Your Ref 2026/90254
Our Ref CRTR-PLAN-2026-46112
Thursday 12 February 2026

Proposal: Discharge of details reserved by conditions 3 (Phase II Intrusive Site Investigation Report), 7 (EV Charging Point), 8 (retaining structures foundations), 9 (CEMP), 10 (retaining walls and boundary treatments details), 11 (invasive species protocol), 12 (foul, surface water and land drainage scheme), 13 (1 in 100 year storm events), 15 (oil/petrol interceptor), and 17 (bat and bird box) on previous permission 2021/90605 for erection of an industrial building (B1(c) use)

Location: land at, Vanguard Processing Equipment, Spa Fields Industrial Estate, Slaithwaite

DETAILED SECTION D-D - CALLOUT

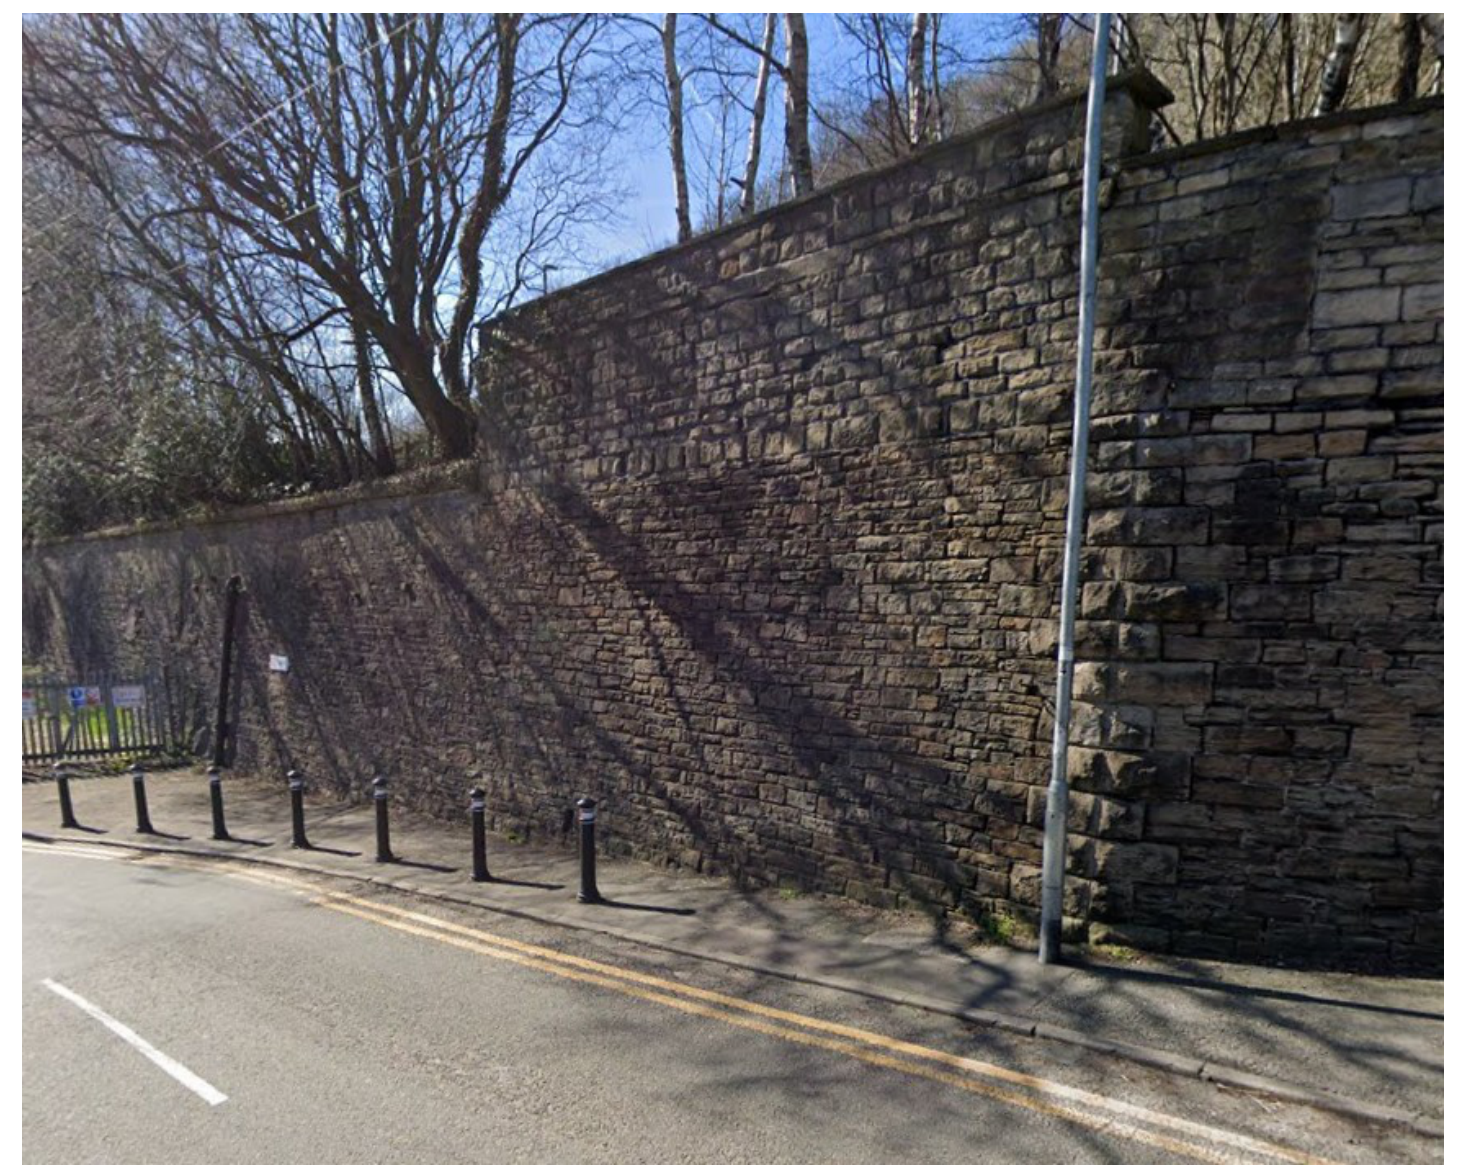
The Trust would require cross sections showing the relationship between the retaining wall and the canal edge (ideally showing the canal at full depth). This is necessary to allow us to calculate the zone of influence, to work out if the retaining walls shown are likely to result in loading upon the wash walls of the canal. Any adverse loading could adversely impact local land stability, and would need appropriate mitigation through the final design detail should this be a risk.

We therefore request that this condition should not be discharged unless the above detail is supplied and assessed.
